## **Arrangements for Handling Heritage Applications Direction 2015**

**1-5 Park Street, Hatfield, Hertfordshire, AL9 5AT**  
**Application No. 6/2020/1028/LB**

PROPOSED
1st FLOOR
WALL DETAIL

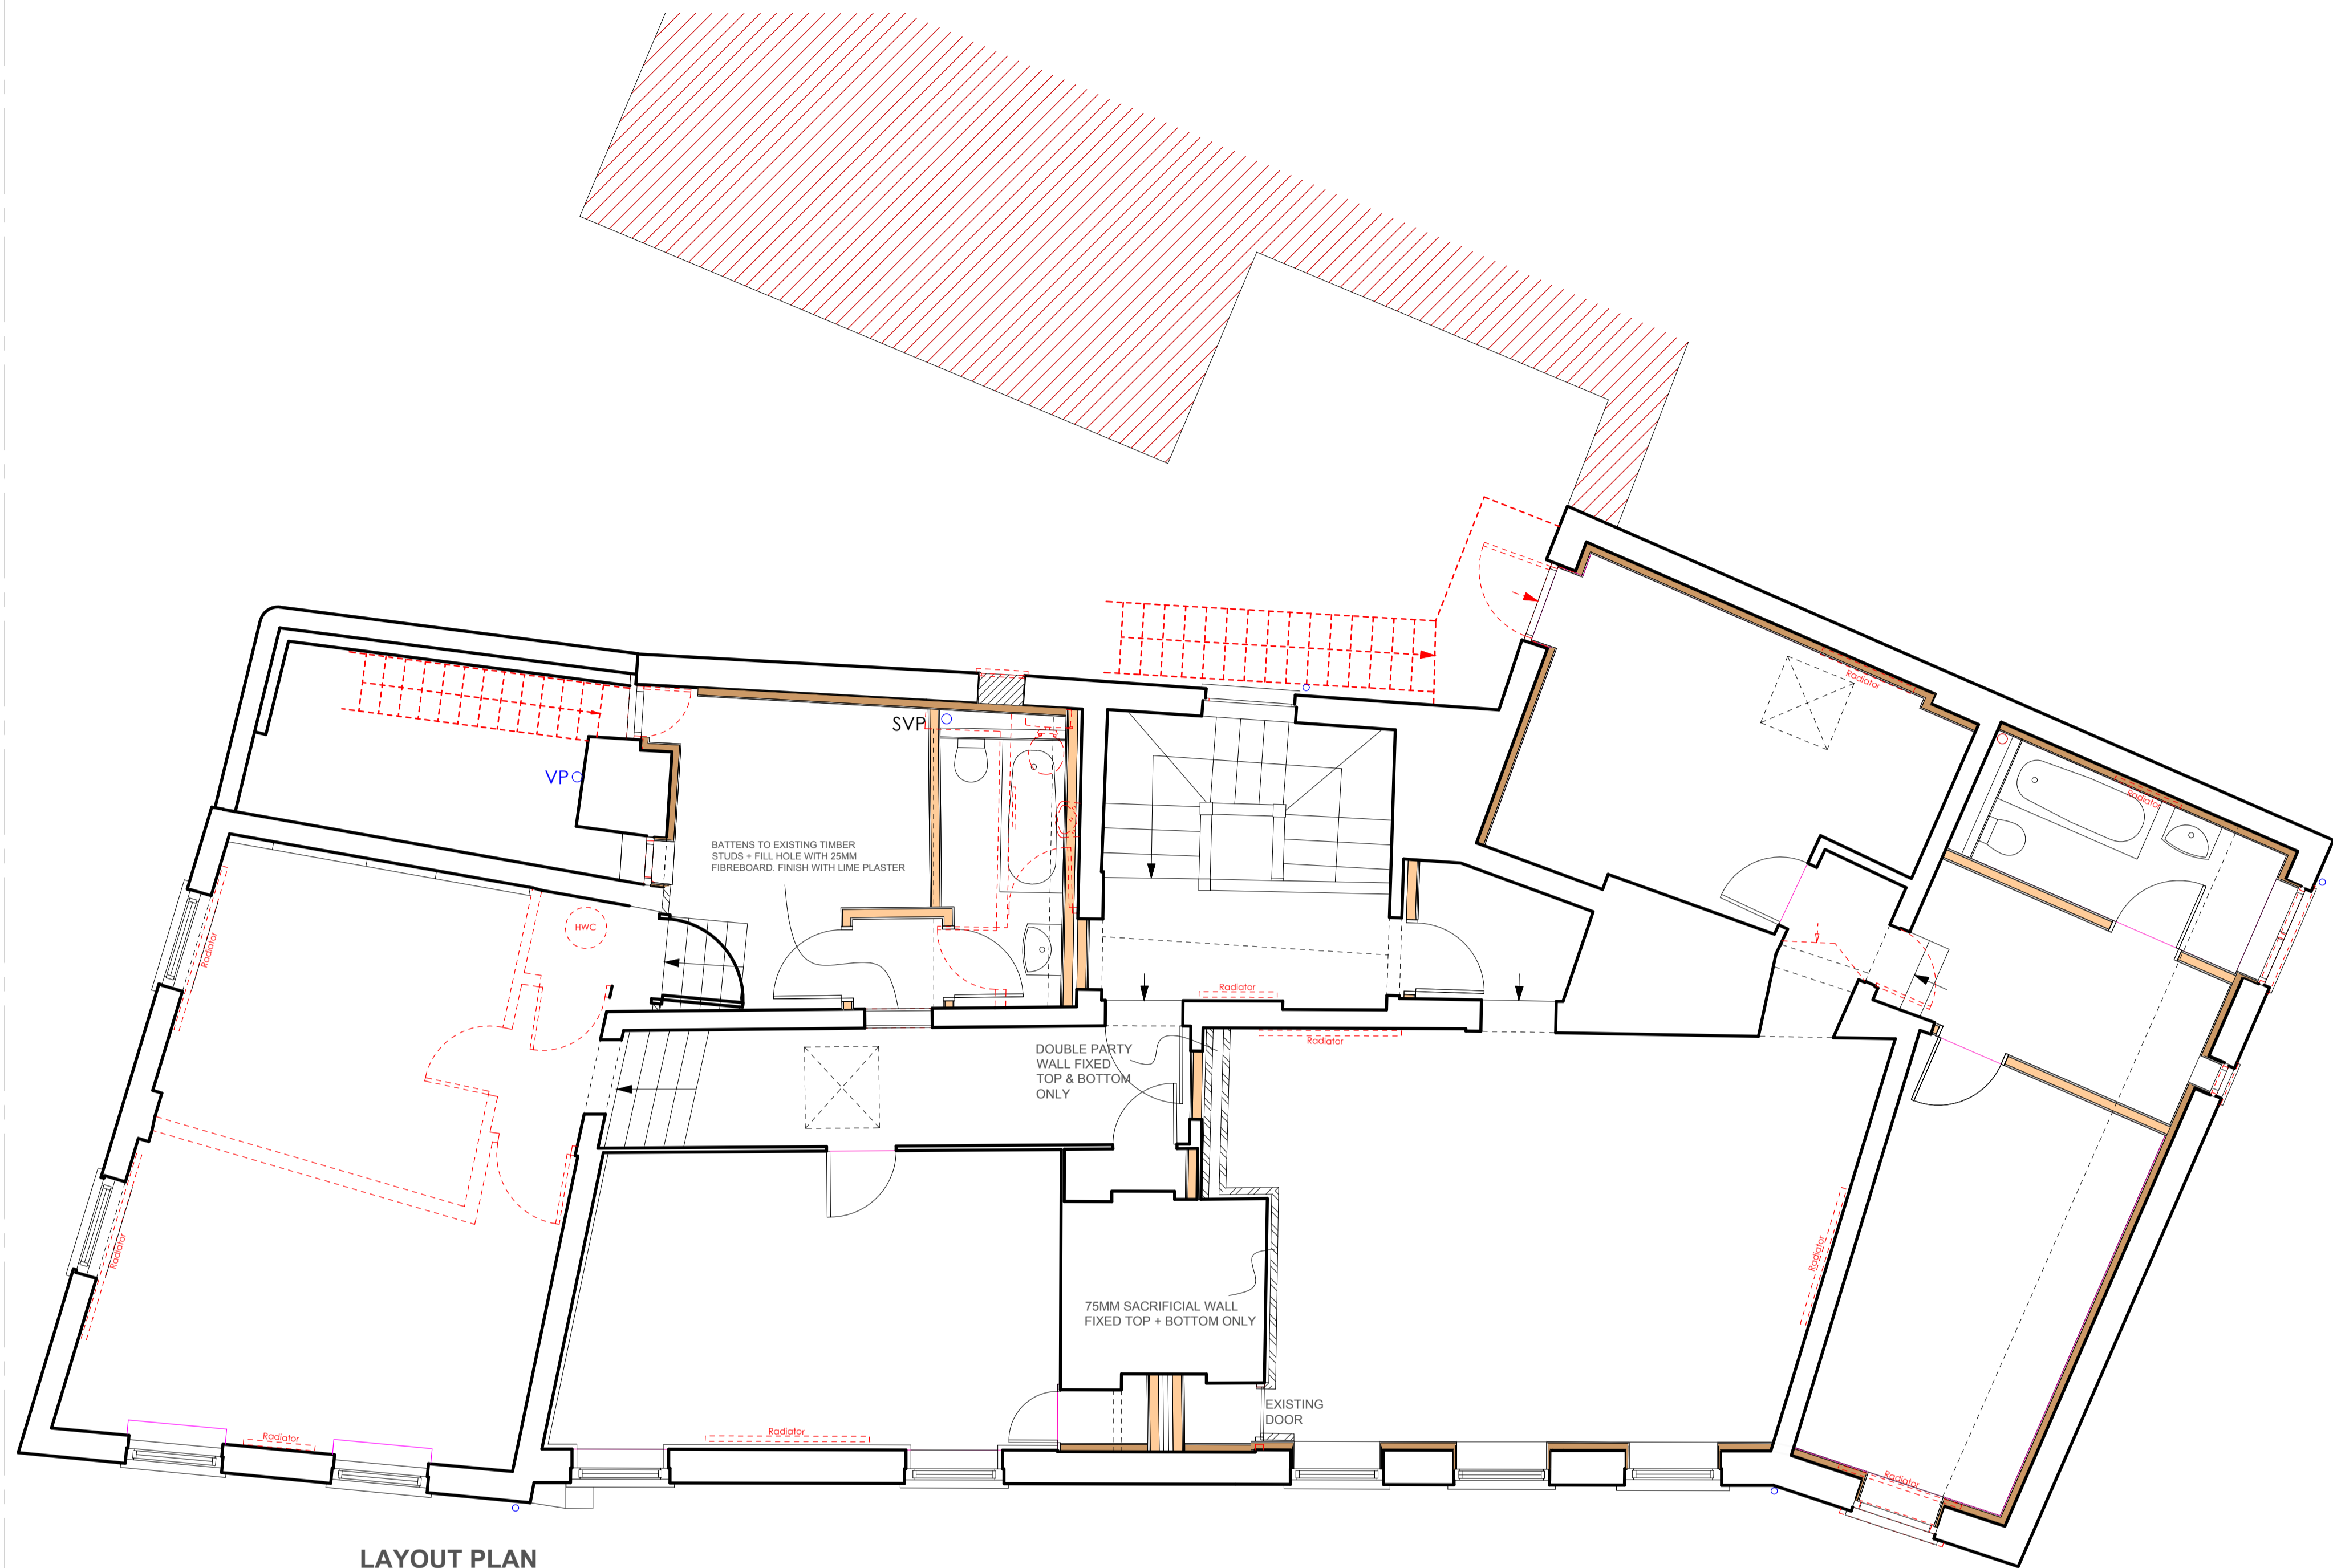
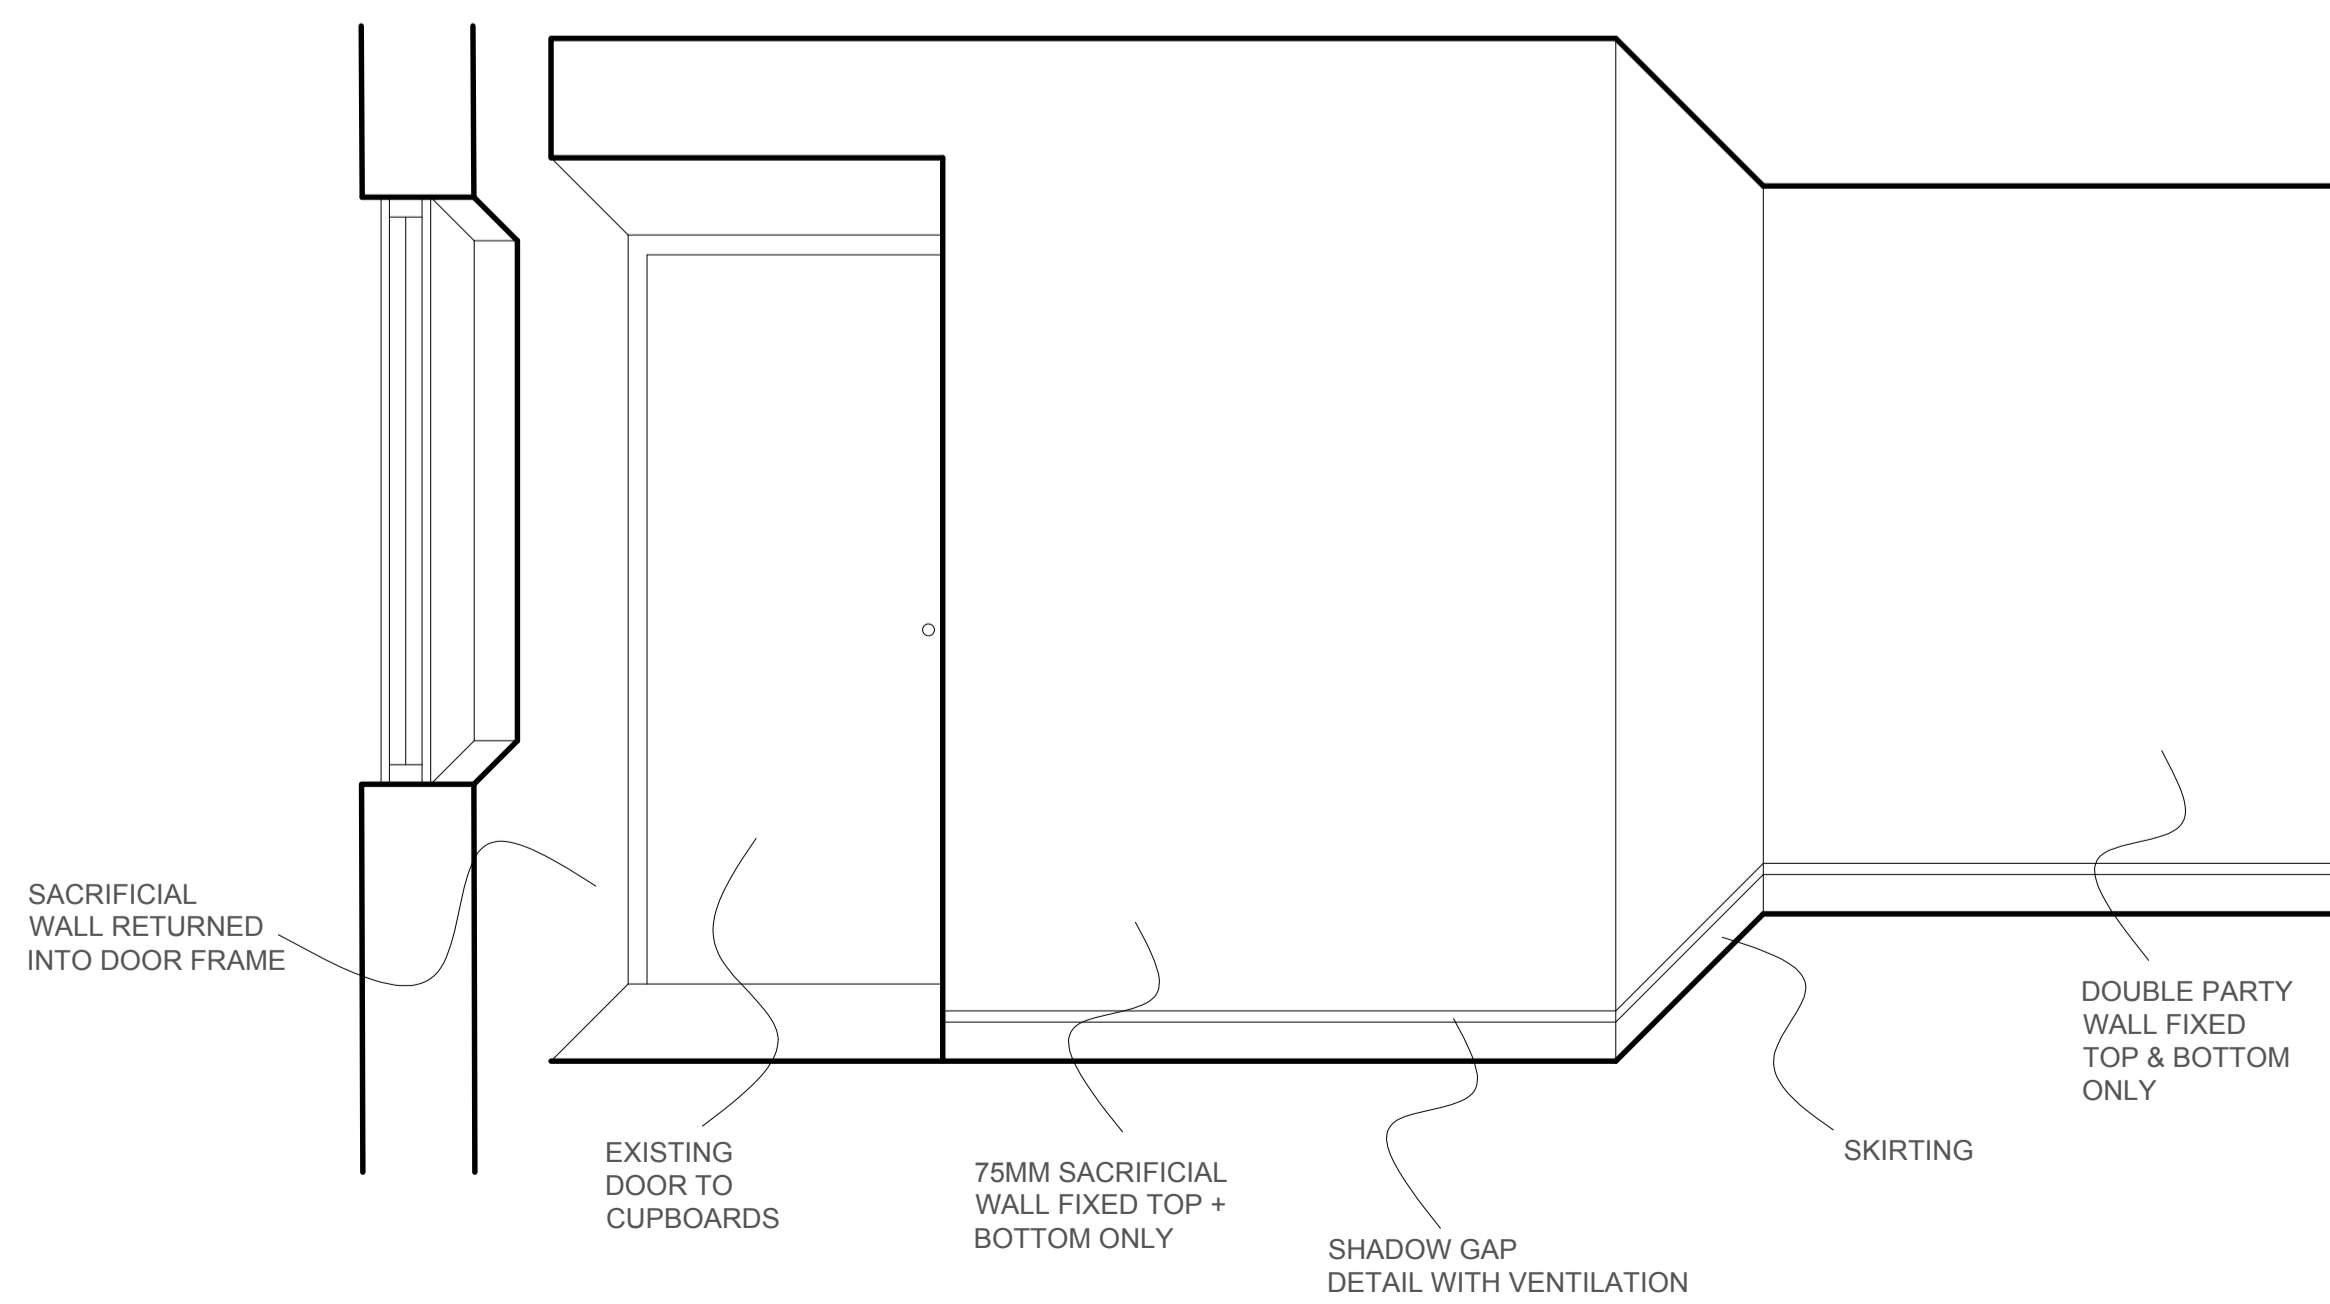
A full archaeological report has been provided which records the building but no information has been provided of the fixing of the woodfibre board to the building. This should be provided.

We do however ask that consideration be given to a condition requiring the details of fixing of the wood fibre board to the surrounding lathe and plaster be provided.
